Cottam Solar Project

Statement of Common Ground with Upper Witham Internal Drainage Board

PINS Ref: EN010133

Document reference: EX1/C8.3.7

### Figure 8.16.2: Landscape and Ecology Mitigation and Enhancement Plan – Cottam 1 North (Sheet 2) Revision A

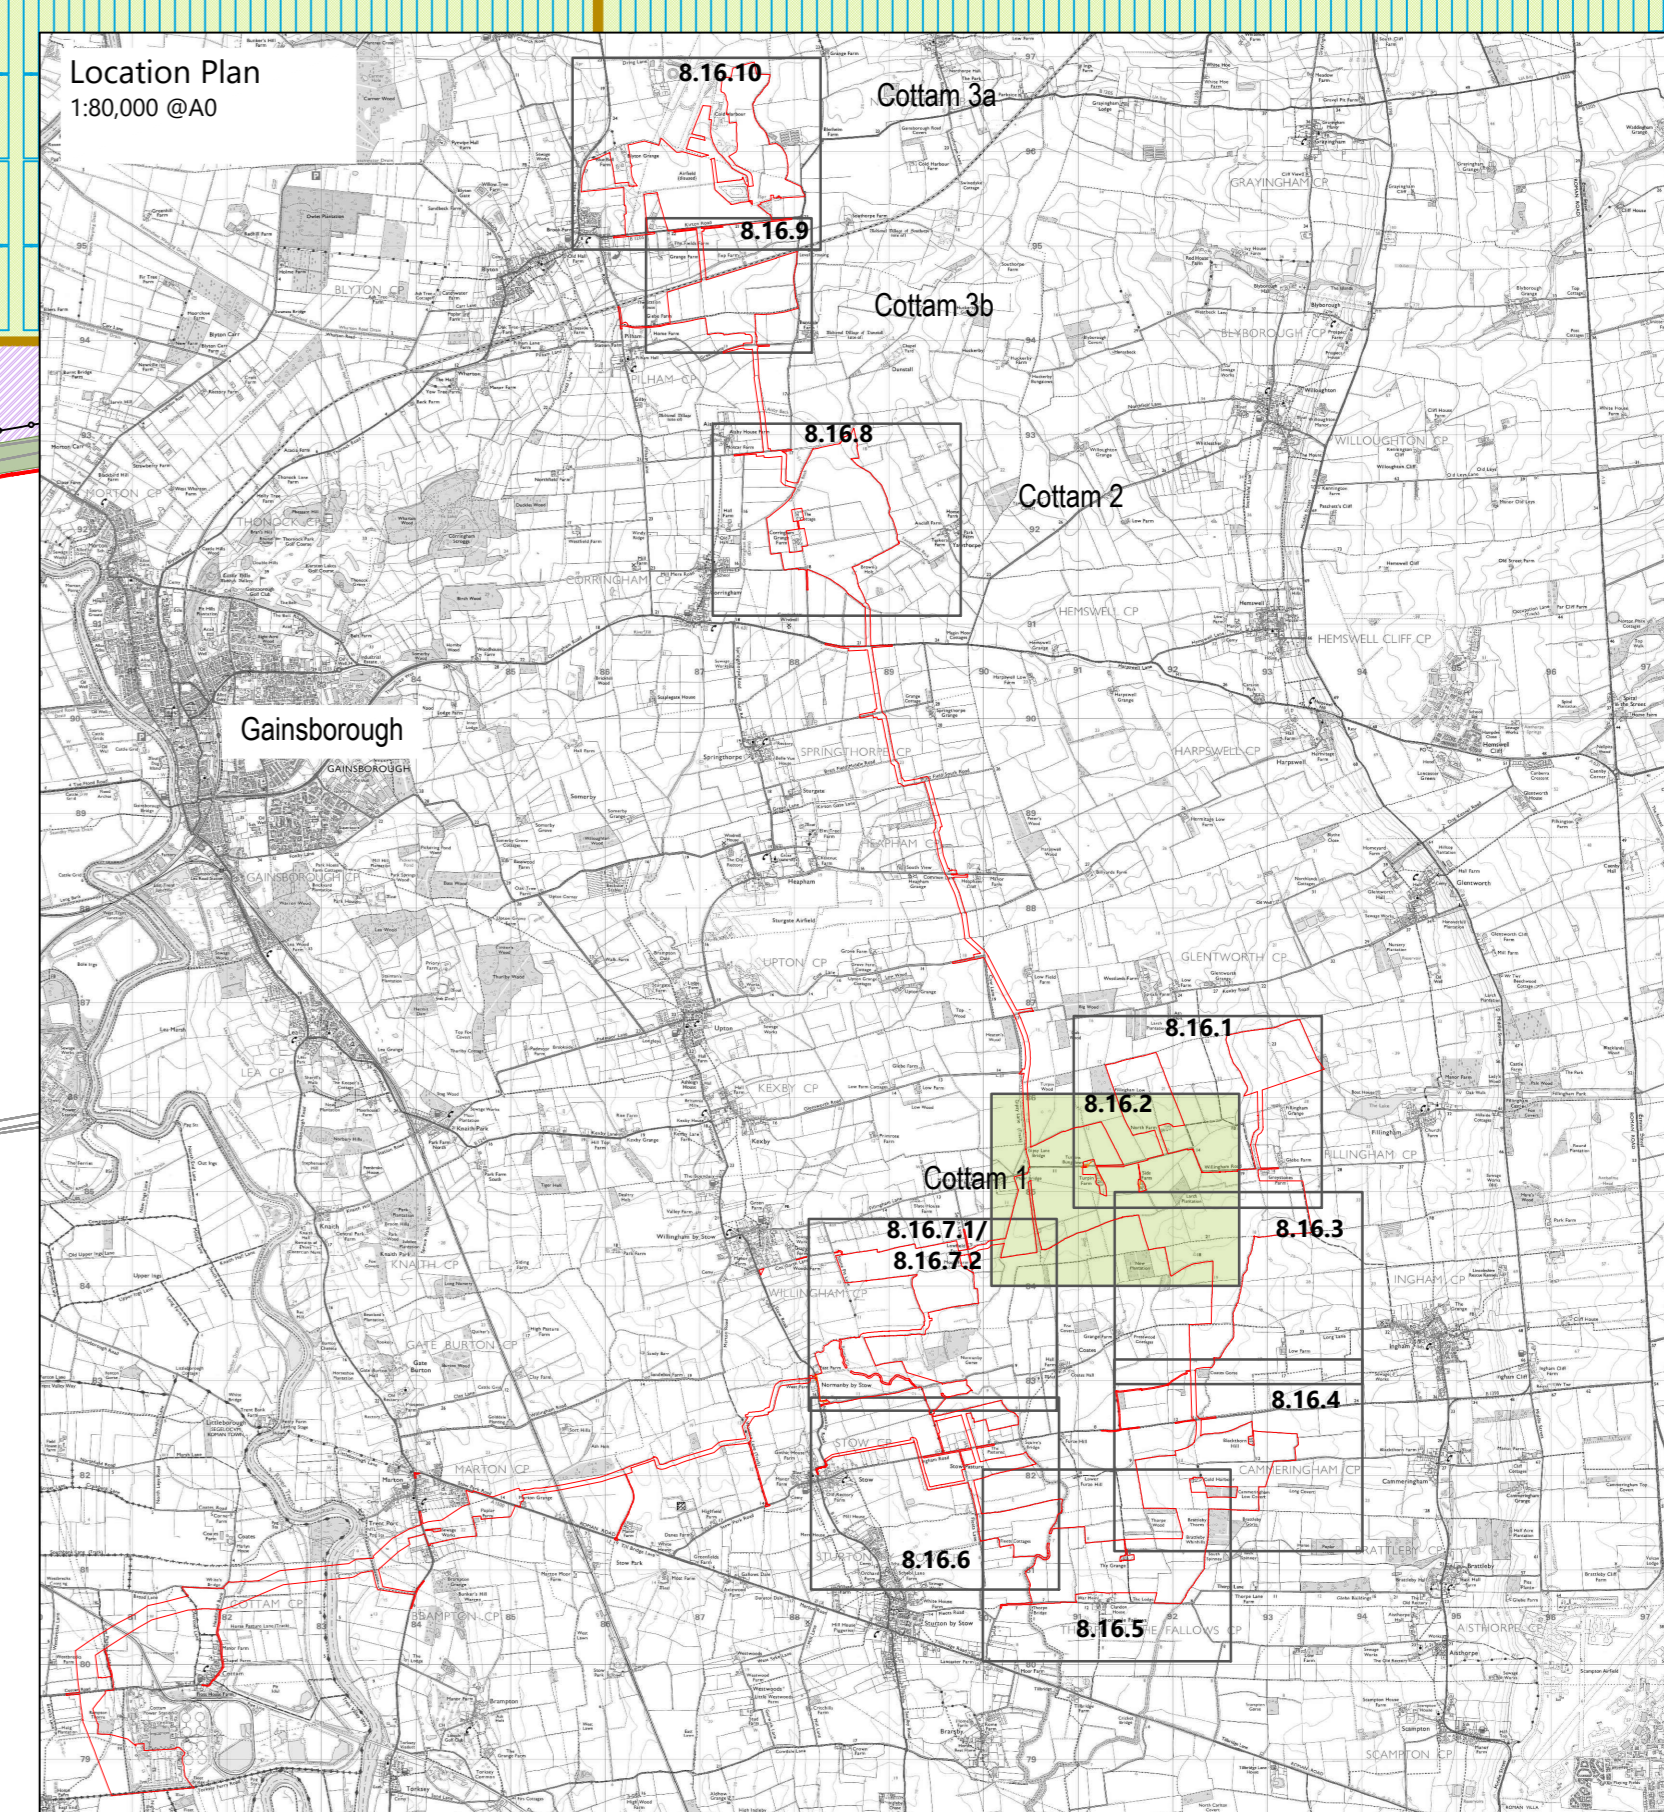
<p><u>Hydrology</u> <u>HY-03</u></p>	<p>Identification of Watercourses</p>	<p><i>"Figure 8.16.2: IDB watercourses not clearly identified. 0502 - Fillingham South Drain. Fencing, planting and potentially solar panels within the 9m Byelaw distance (from the top of the bank) preventing access for maintenance</i></p>	<p>These IDB watercourses and drains have been considered throughout the layouts with a 9m offset as has been possible and as shown on Landscape and Ecology Mitigation and Enhancement Plans (Figures 8.16.1 to 8.16.10) [APP-305 to APP-315]. The Applicant has discussed this matter with the IDB and both parties are in agreement that the scale of the Scheme makes it impossible to provide the full</p>

### Figure 8.16.3: Landscape and Ecology Mitigation and Enhancement Plan – Cottam 1 North (Sheet 3) Revision A

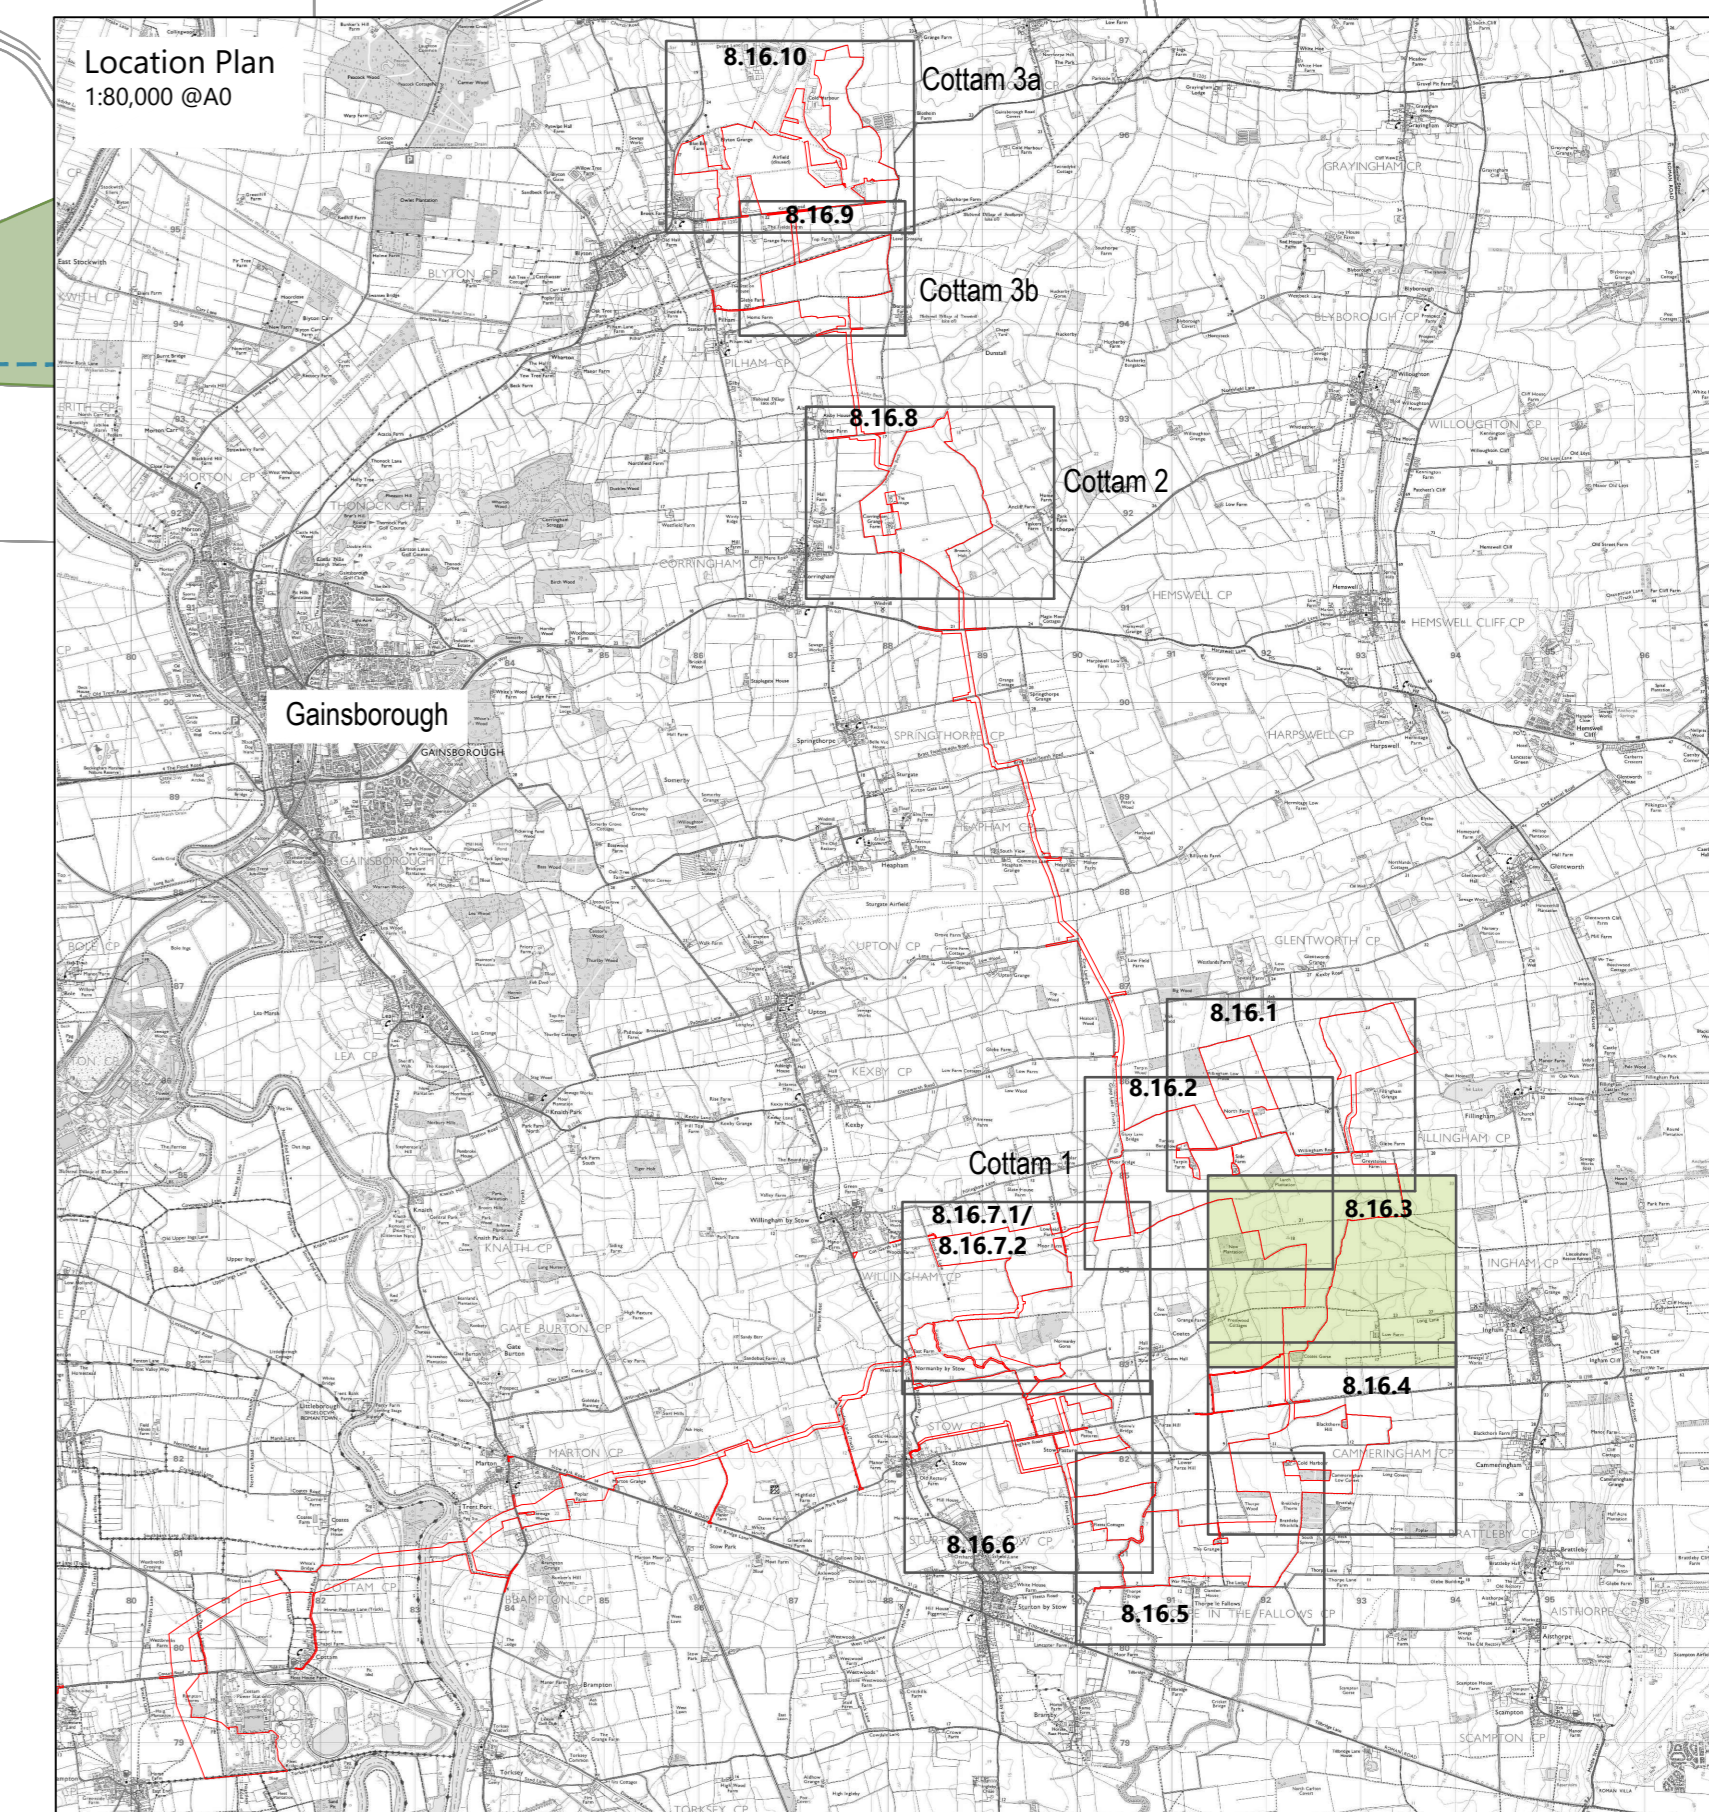
<p><i>0500 - East Till. Fencing, planting and potentially solar panels within the 9m Byelaw distance (from the top of the bank) preventing access for maintenance.</i></p> <p><i>Figure 8.16.3: IDB watercourses not clearly identified.</i></p> <p><i>0600 - Cammeringham Drain. Fencing, planting and potentially solar panels within the 9m Byelaw distance (from the top of the bank) preventing access for maintenance.</i></p> <p><i>Figure 8.16.4: IDB watercourses not clearly identified.</i></p> <p><i>0600 - Cammeringham Drain. Fencing, planting and potentially solar panels within the 9m Byelaw distance (from the top of the bank) preventing access for maintenance.</i></p> <p><i>Figure 8.16.5: IDB watercourses not clearly identified.</i></p> <p><i>0700 - Cricket Till. Fencing and potentially solar panels within the 9m Byelaw distance (from the top of the bank) preventing access for maintenance.</i></p> <p><i>Figures 8.16.7.1 & 2: IDB watercourses not clearly identified.</i></p> <p><i>0500 - East Till. Fencing, planting and potentially solar panels within the 9m Byelaw distance (from the top of the bank) preventing access for maintenance.</i></p> <p><i>0400 - Padmoor Drain. No comments.</i></p>	<p>information regarding detailed design at this stage.</p> <p>The Applicant notes that the drawings are based on the currently available data and mapping and in some cases the 'top of bank' is not defined. It notes that further survey work will be required to establish the 'top of bank' which will in turn give the 9m offset and required clear working access. The IDB can provide a shape file to confirm the locations during the detailed design stage post DCO consent.</p> <p>The Applicant will then provide a specific plan to the IDB at the detailed design stage (post DCO consent) to give clear details of all 9m offsets to the IDB's maintained watercourses and drains.</p>

Figure 8.16.6: Landscape and Ecology Mitigation and Enhancement Plan – Cottam 1 West (Sheet 1) Revision A

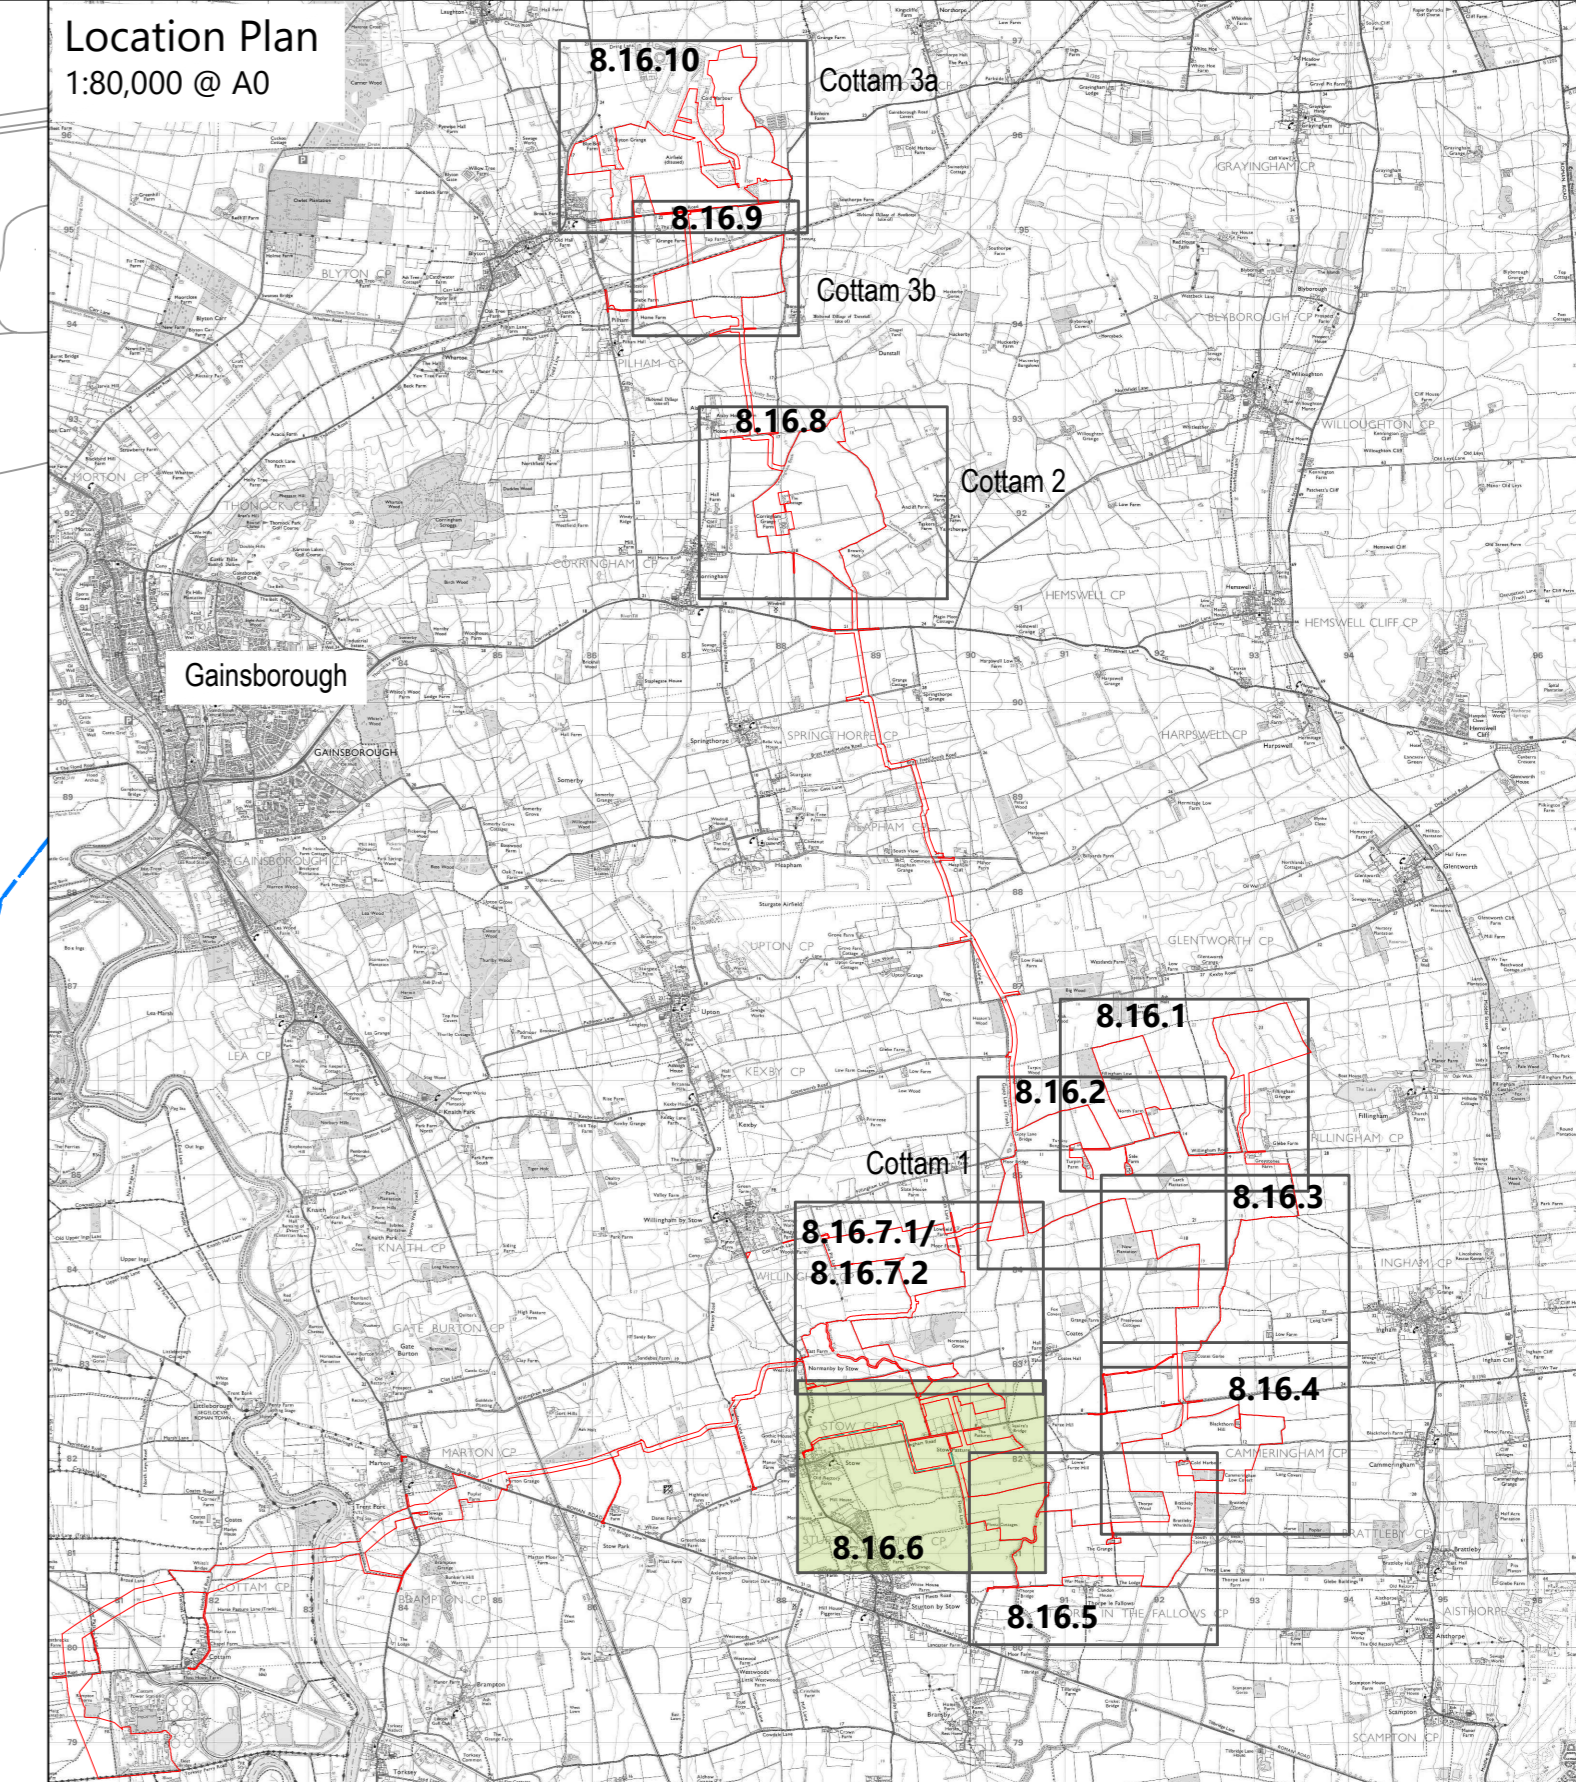
<p><i>0106 - Throops Drain. Fencing, planting and potentially solar panels within the 9m Byelaw distance (from the top of the bank) preventing access for maintenance.</i></p> <p><i>Figure 8.16.6: IDB watercourses not clearly identified.</i></p> <p><i>0106 - Throops Drain. Fencing, planting and potentially solar panels within the 9m Byelaw distance (from the top of the bank) preventing access for maintenance.</i></p>	
<p><u>Hydrology</u> <u>HY-04</u></p>	<p>Provision of Works</p>	<p><i>Provision of any culverts, outfalls and other works within all watercourses (apart from Environment Agency main river.)</i></p> <p><i>Within the Upper Witham IDB district under the terms of the Land Drainage Act. 1991 the prior written consent of the Board is required for any proposed temporary or permanent works or structures within any watercourse including infilling or a diversion.</i></p> <p><i>Within the extended area of Upper Witham IDB under the provisions of the Flood and Water Management Act 2010, and the Land Drainage Act. 1991, the prior written consent of the Lead Local Flood Authority (Lincolnshire County Council) is required for any proposed works or structures in any watercourse outside those designated main rivers and Internal Drainage Districts. At this location this Board acts as Agents for the Lead Local Flood Authority and as such any works, permanent or temporary, in any ditch, dyke or other such watercourse will require consent from the Board.</i></p>	<p>The IDB have asked for this item to be included within the Statement of Common Ground. The Applicant notes the requirements and will ensure that the project adheres to these as and when required. Protective provisions for the benefit of the IDB are included in part 8 to Schedule 16 of the draft DCO [AS-012] which require that the IDB be consulted and approve any “specified works” within 9m of any of the IDB’s drains/watercourses.</p>
